From: [Borough Planning](#)
To: ["Andy Derrick"](#)
Subject: RE: Additional information required for 22/00977/F
Date: 03 August 2022 08:59:56

We have received two location plans (Title plan and Land Registry) with two different red lines, please amend your Location plan and a Block plan. The location plan should be to scale of either 1:1250 or 1:2500 edging the site in question in red and any other adjoining land in applicant's ownership in blue. Unfortunately Block plan to scale of 1:400 is not acceptable, block should be to scale of either 1:200 or 1:500 and show proposed works "from birds eye view" and have red lines around the development site. You can purchase these plans online at www.planningportal.co.uk - Attached

# Rose Lodge Site/Block Plan

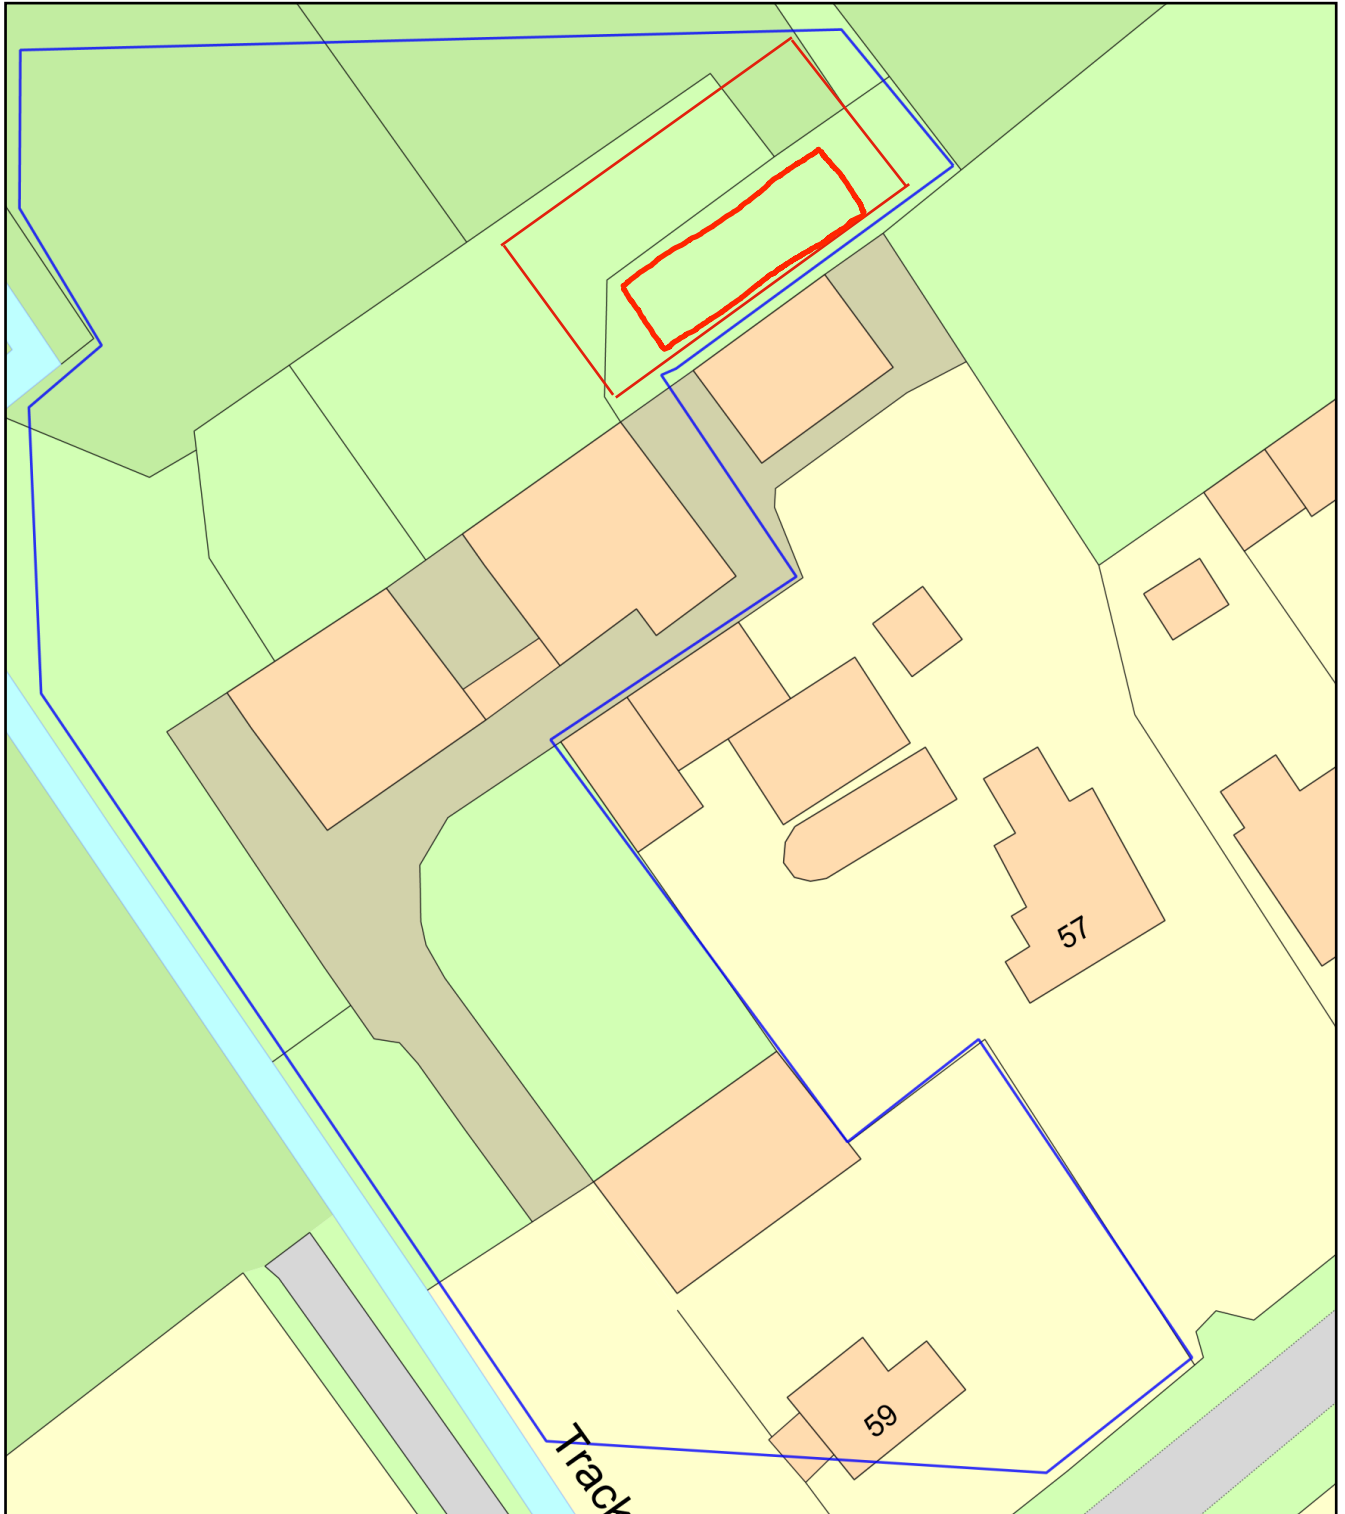
Please find attached example sketch showing what we are looking for, red line outlining the site in question and a blue line edging other land in applicant's ownership. Please note that location plan should show all boundaries of your holding, you can extend your plan to 1:2500 or 1:5000. Similarly, please amend the Block plan
